PORTLAND MAINE

March 20, 2008

RE: 461 Woodford Street – 176 B003 – R-5 – illegal deck – permit #08-0249

## 459-461 Woodford

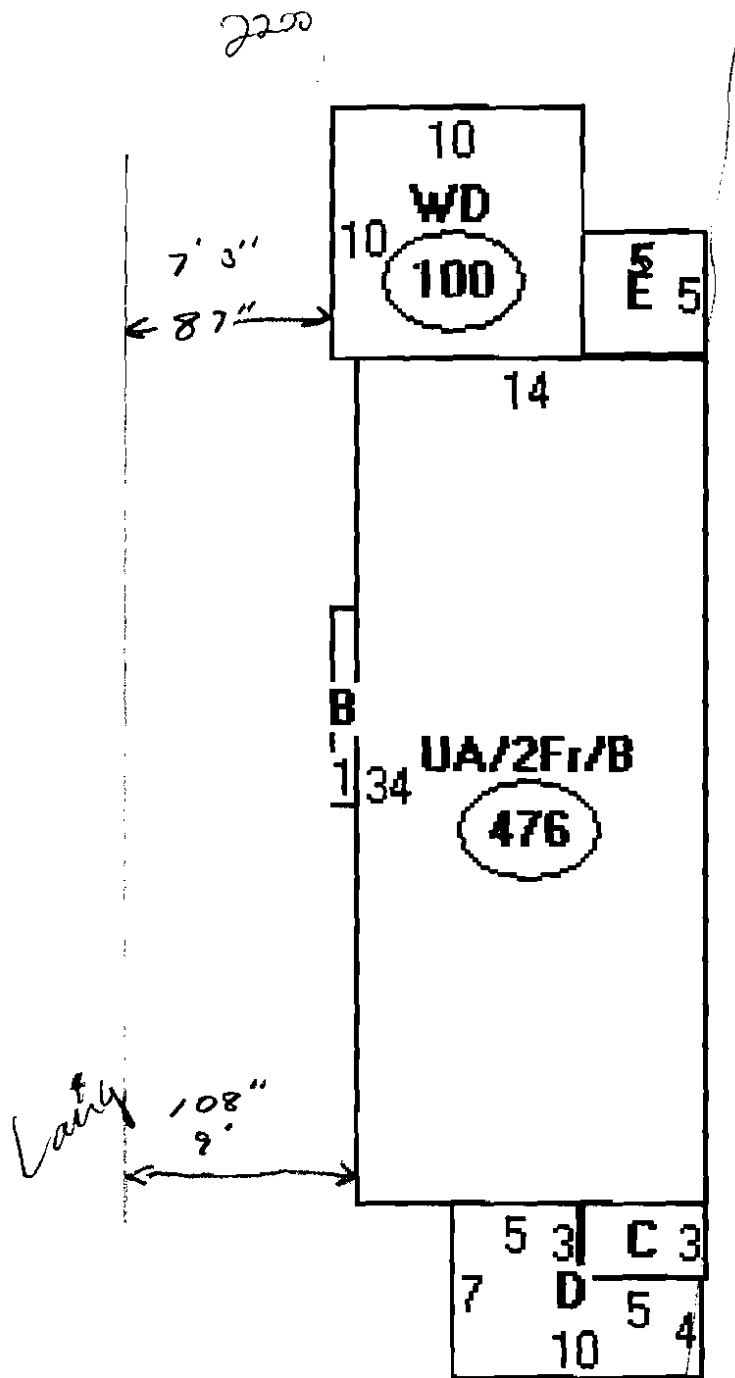
This letter is a follow up to our telephone conversation from earlier today. As I told you, there is no record of a permit being applied for to build the existing ten-foot by ten-foot deck on the rear of your property. Since no permit was applied for, the deck is not legal and you have no right to it. Your property is located in the R-5 residential zone. Section 14-120(d)(3) of the ordinance states that the side setback for a single story structure is eight feet. The plot plan submitted with the permit gave the side yard setback to the deck as seven feet, three inches, so it does not meet the side setback requirement. Section 14-120(b) lists the minimum lot area required per dwelling unit in the R-5 zone as 3,000 square feet. The square footage of your lot is 2,200 square feet. Section 14-388 of the ordinance says “a building nonconforming as to the regulations governing area per dwelling unit shall not be enlarged unless such building including such addition or enlargement, is made to conform to all the area per dwelling regulations of the zone in which it is located.” Your lot does not conform to the required area per dwelling unit, so you may not enlarge your building by adding a deck. Since a permit was not issued to build the deck and section 14-388 does not allow you to expand your building, the deck must be removed.
